Our Case Number: ABP-309770-21

**Re: Proposed development of up to 15 wind turbines with a tip height of up to 175 metres and laying of approximately 26km of underground electricity cabling to facilitate the connection to the national grid, and all associated site development works
Townlands of Camagh, Carlanstown, Coole, Clonrobert, Clonsura, Doon, Monktown, Mullagh, Newcastle and other townlands, Co. Westmeath**

Please find attached an Observation on Further Information on case Nos 309770-21 Coole Wind Farm SID.

Drawing Notes

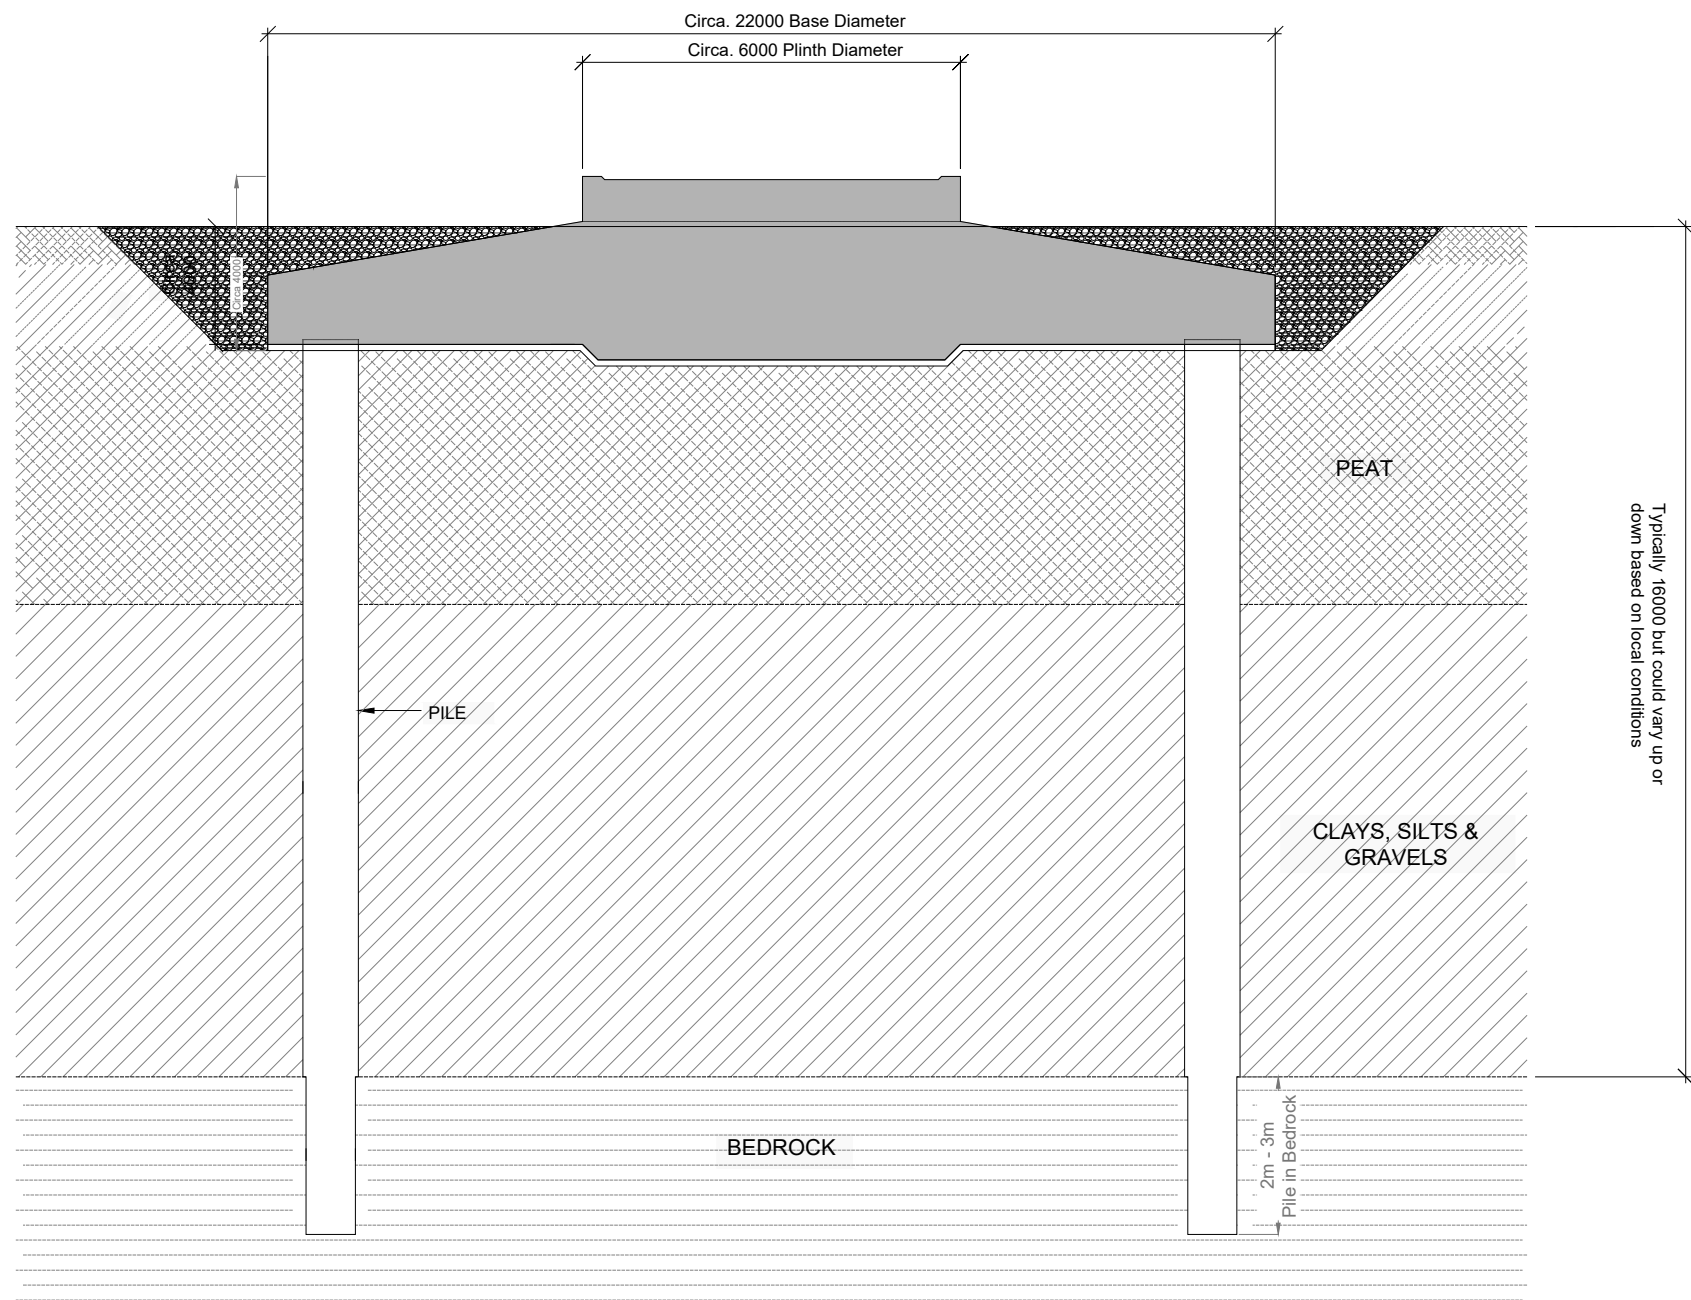
- 4. There is nothing “reasonably limited” about the range as claimed above. The facts are there is a 6m difference in rotor diameter which is over 20 feet. This is a significant increase in the size of the turbine so how is it that planning permission can be permitted for three different turbine configurations with this much of a width variation?**
- 5. Why would such latitude be given to an industrial wind farm development and how does this compare to revised planning applications with similar size increase for structures such as houses etc?**

- 6. The above point begs the question would such a range difference be allowed in a residential or commercial building in either an urban or rural settings and if not why should they be deemed acceptable for a windfarm**
-

- 7. In the above statement, it should be again highlighted that the CWF SID seems to be claiming a 20-foot difference in rotor diameter is not significant or that the scale of these giant industrial turbines is already so massive that an additional 20-foot difference would matter little in terms of its impact on the environment. Can they confirm if this is the case?**
- 8. Will CWF state more precisely, and in clearer language, that our interpretation of what they are claiming is either correct or incorrect what exactly do they mean?**
